## PLANNING CONSULTATION RESPONSE

<b>Application No</b>	2025/1062
<b>Proposal</b>	Demolition of existing domestic garage and formation of new driveway/parking, and outline permission for the erection of 4 houses within the residential garden.
<b>Address</b>	Land adjacent to 1A West Street, Worsbrough Bridge, Barnsley, S70 5PG
<b>Date of Consultation Reply</b>	12/03/26
<b>Consultee</b>	Highways Development Control

SITE PLAN
SCALE 1:250

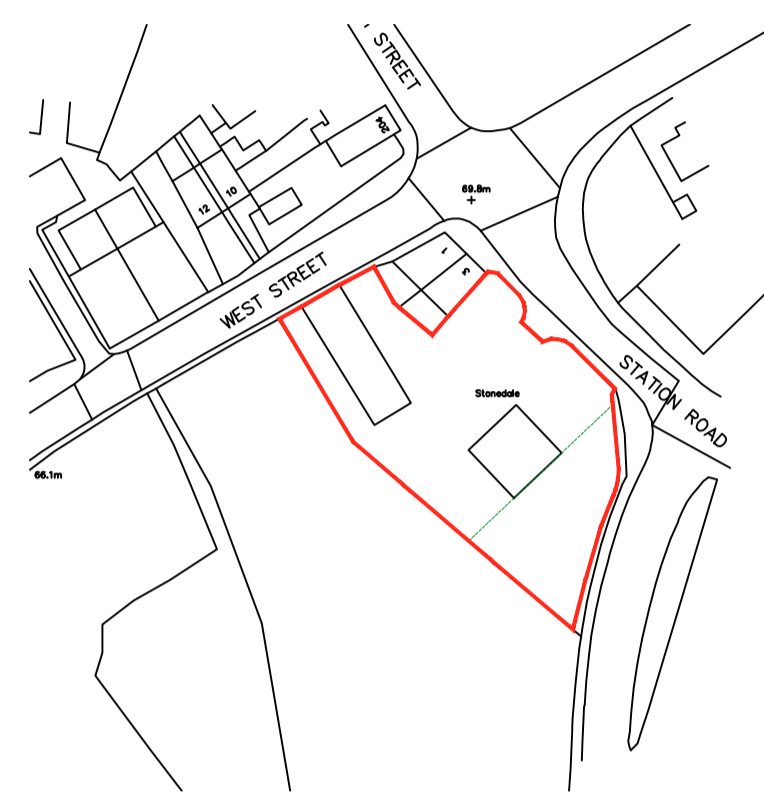
The proposal seeks permission for the construction of four dwellings on land currently forming part of the curtilage and parking area associated with Stonedale. Vehicular access to the development would be taken from the existing access serving the Stonedale parking area from West Street, with the proposed dwellings served via a short internal shared private drive.

The existing access is well established and already serves the Stonedale property and its associated parking area. The proposal does not seek to introduce a new point of access onto the public highway and would therefore utilise the existing access arrangement. Given the scale of development proposed, the additional traffic likely to be generated by four dwellings would be limited and would not be expected to result in any material impact on the safety or operation of the surrounding highway network.

The submitted layout indicates that each of the proposed dwellings would benefit from allocated parking provision with adequate turning area to ensure vehicles can leave the site in a forward travelling direction. The level of parking provision shown is consistent with the requirements set out within the Barnsley Parking SPD.

Parking provision for the donor property, Stonedale, has also been incorporated within the layout. Three parking spaces are shown allocated to the property on land that previously formed part of the existing lawned garden area. This provision is considered sufficient to

serve the existing dwelling and ensures that the proposed development would not result in the loss of parking associated with the donor property.

On this basis, there are no objections from a Highways Development Control perspective subject to the conditions and informatives listed below.

Before the development is brought into use, that part of the site to be used by vehicles shall be surfaced in a bound, solid material and adequate measures shall be so designed into the proposed access to avoid the discharge of surface water from the site on to the highway. Reason: To ensure adequate provision for the disposal of surface water and to prevent mud/debris from being deposited on the public highway and to prevent the migration of loose material on to the public highway to the detriment of road safety.
